CITY OF ALBUQUERQUE

May 30, 2013

Re: Duggers Towing, Grading and Drainage Plan
Engineer's Stamp Date 05-28-2013 (D-18/D034)

**Re: Revised Drawing - Duggers Towing, Grading and Drainage Plan,
Engineer's Stamp Date 04-02-2013 (D-18/D034)**

# G1

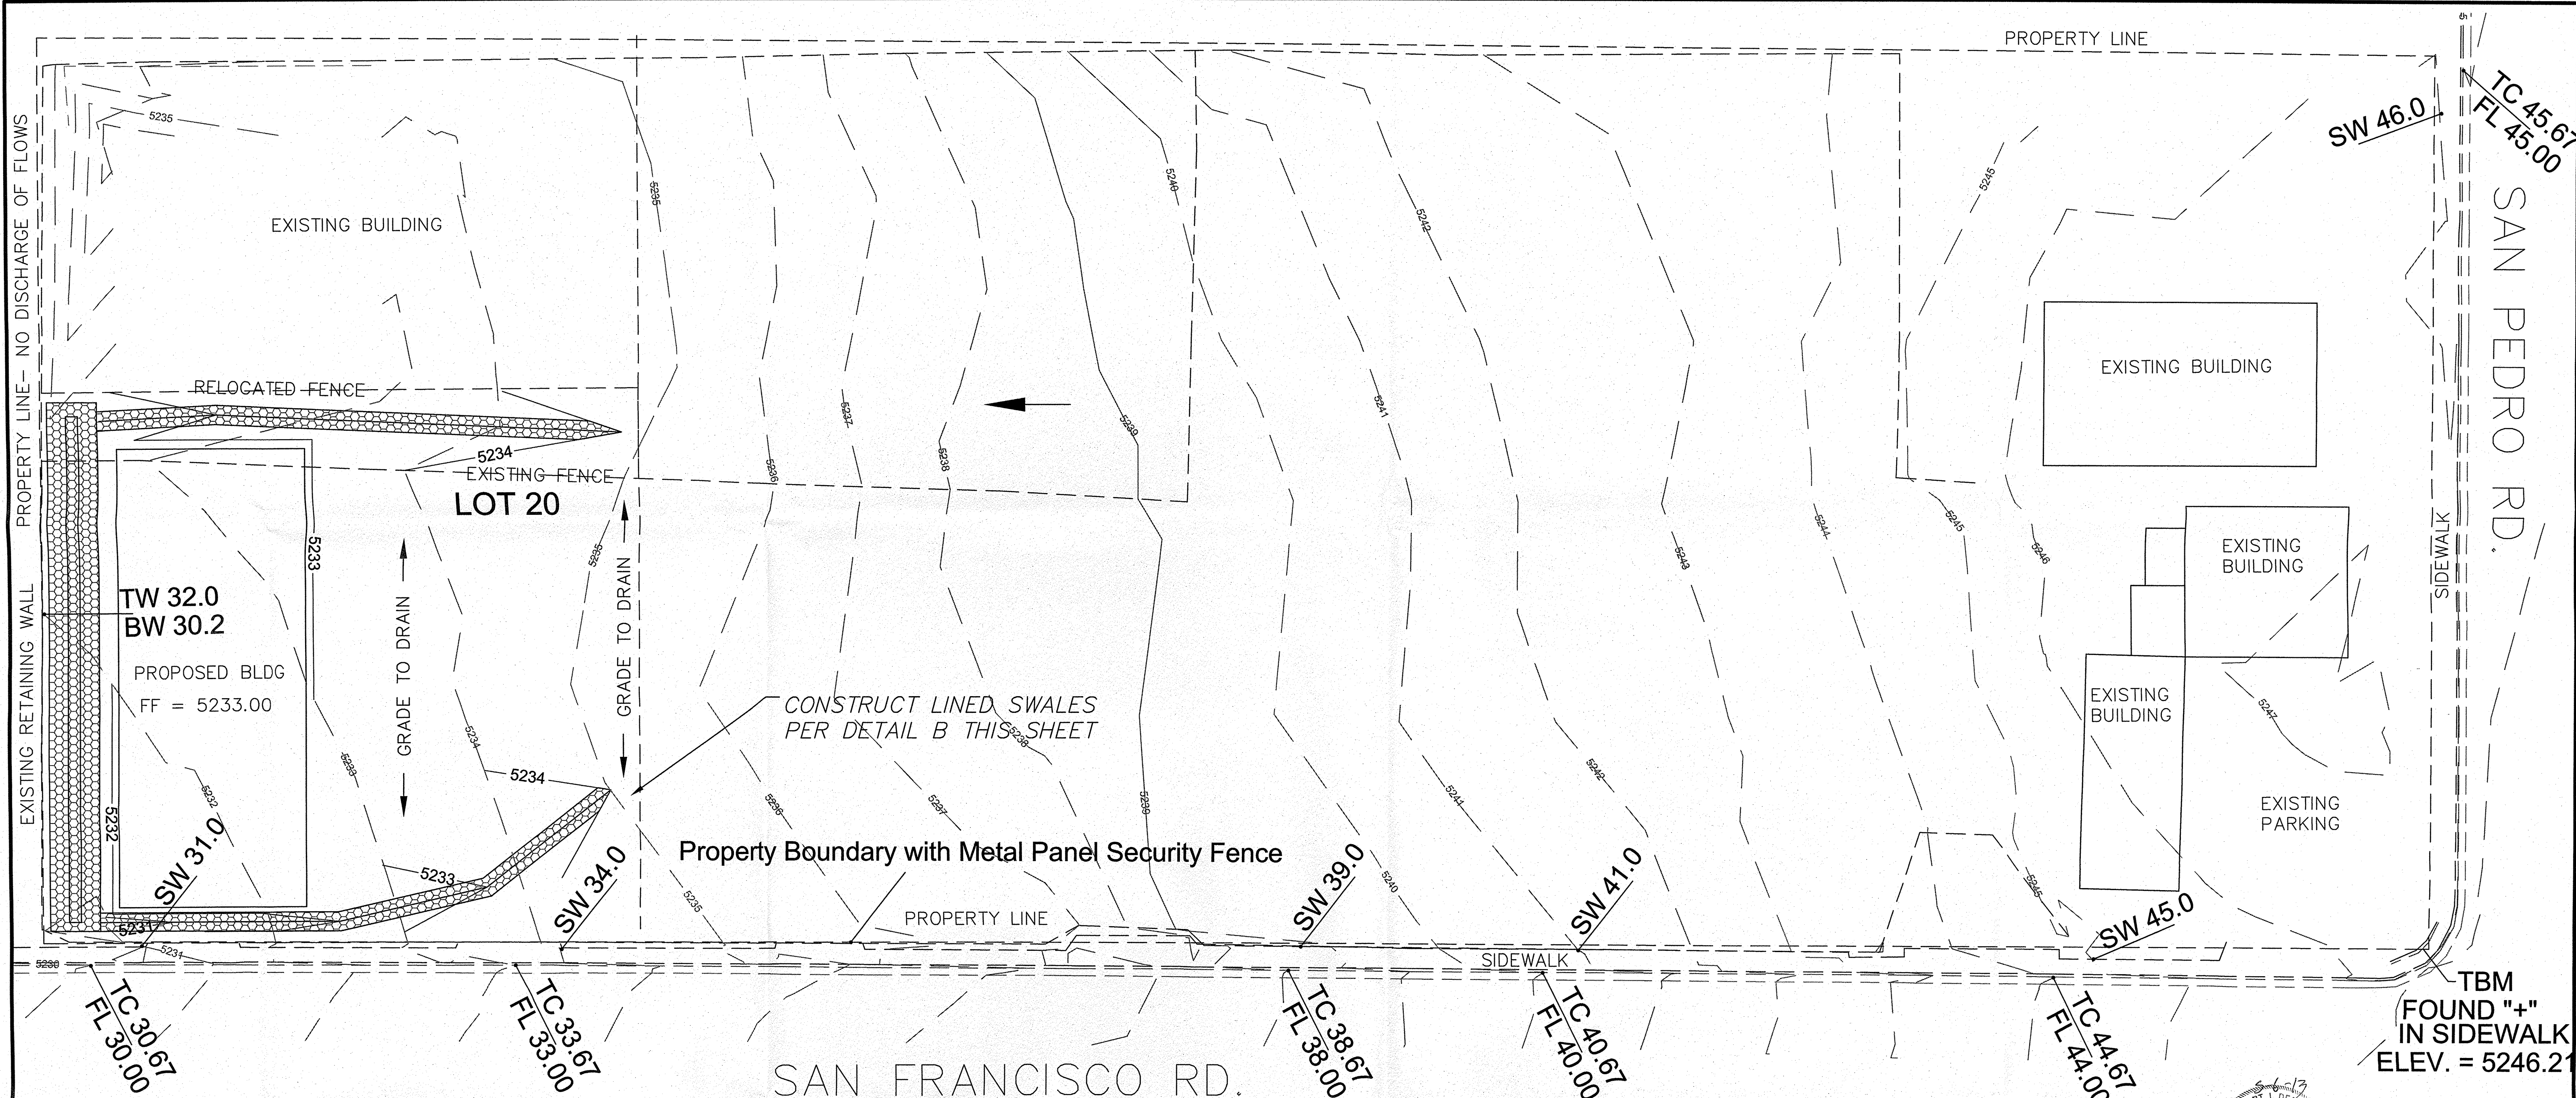
- Please quantify all off-site flows being received and show how these flows will leave the site.

- Provide additional spot elevations of the site interior as well as extend contours and show additional spots to the west of the property.

- Clarify the property boundaries; show all sidewalk, curb and gutter elevations and flowlines along San Francisco Drive.

- The proposed retention pond will be required to hold the full 10-day volume of developed and concentrated flows from the site; Hydrology suggests the implementation of a detention pond with ultimate discharge through a sidewalk culvert onto San Francisco Drive.

- How will the channelized flows be directed around the bends into the proposed pond without topping over?

- Will there be any parking requirements for the proposed building?

- Provide a benchmark designation on the grading plan.

The site is isolated from offsite flows by curb & gutter along San Pedro, San Francisco and Pino. Flows from adjoining private property immediately to the north are prevented by CMU walls, corrugated metal security fence, and existing grading. Additionally, an existing metal-panel security fence along the south and west side property line prevents discharge of flows along the west and south sides of the site. The revised drawing quantifies all off-site flows being received, and how these flows are routed to an on-site retention pond.

More detailed contouring is shown in the revised drawing, as well as extended contours and spots to the west. (Private property access was not granted to the west, but we have provided spot elevations where we were able to legally acquire topography)

The property boundaries have been clarified and the requested elevations along San Francisco are shown.

The design hydrology and retention pond design have been revised to retain the 10-day volume, no discharge through sidewalk culvert is planned for the purpose of storm water quality.

The pond has been extended to remove the bends and any possibility of topping over.

There are no parking requirements for the proposed building, it is not open to the public and has no need for parking.

A project benchmark is shown at the corner of San Pedro and San Francisco.

G1

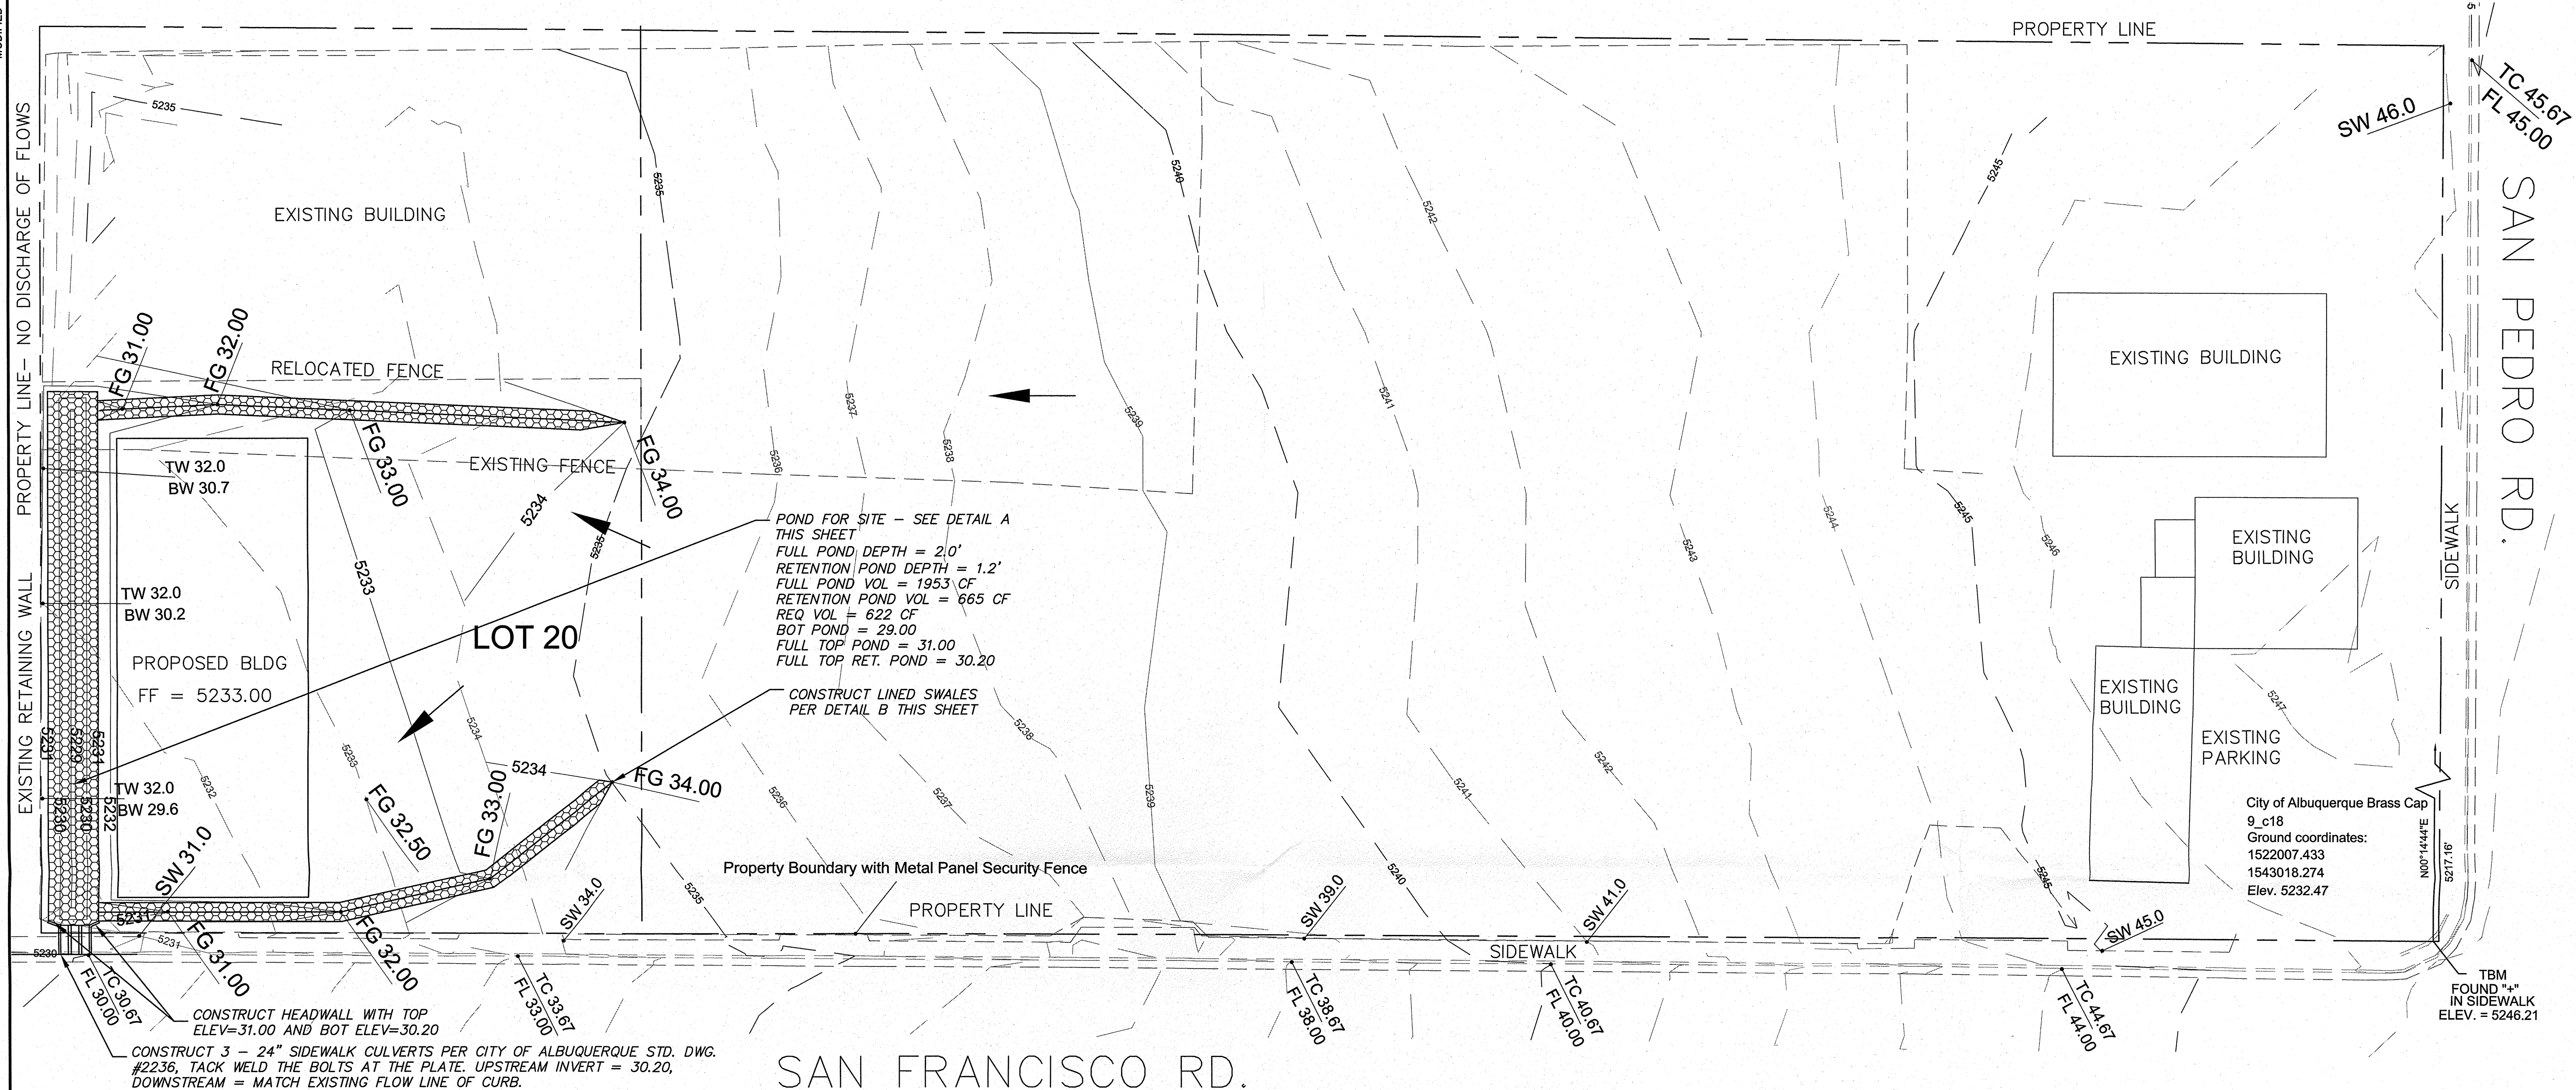
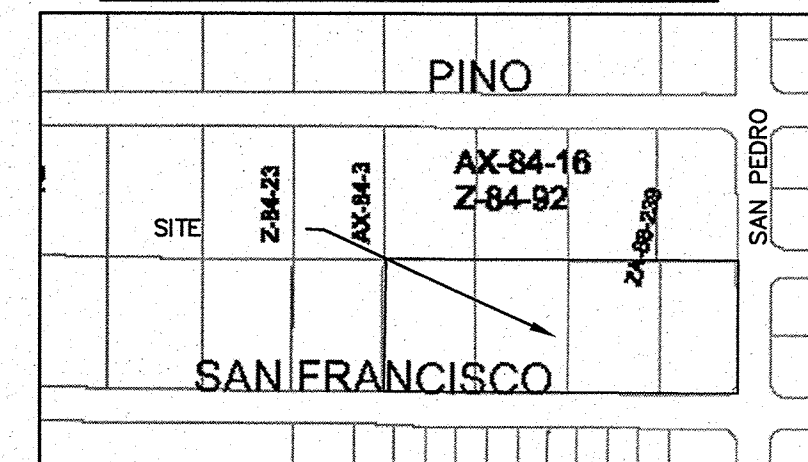
- 1_ Lower the pond so we would retain the developed volume. The invert of the sidewalk culverts and the bottom of the pond are the same elevation.
- 2_ Change the property line to a thicker solid line or phantom for clarification.

- 3_ Extend the sidewalk culvert 2' passed the property line. Add a note to the sidewalk culverts to "TACK WELD THE BOLTS AT THE PLATE".
- 4_ Provide sidewalk culvert capacity calculation.

- 5_ Increase the txt size for the drainage calculations on the plan.
- 6_ Can you redesign the pond to make it a retention/detention pond to limit the discharge so you would only need 2-2' sidewalk culverts? Possibly the top of the pond would be at 31.50 or 32.00 and the bottom may at 29.20 and discharge point at 30.20. Provide a headerwall at the back of the inlet (with the top at 31.5 or 32.0) and opening sized to the sidewalk culvert dimensions.

Mr. Herrington,
The drawing has been revised with the additional information you requested:

Sidewalk culverts
Additional spots and grading showing flowpaths into the swales
Additional spots near the pond and back wall
Datum reference (benchmark)

We have been unable to have the surveyor gain access to the private property along the back wall, but have added the top of wall information and bottom of wall. the proposed top of pond is approximately 1 foot lower than the top of retaining wall on the Duggers site, and the proposed sidewalk culverts will provide positive drainage to the curb and gutter prior to flows topping the back wall.
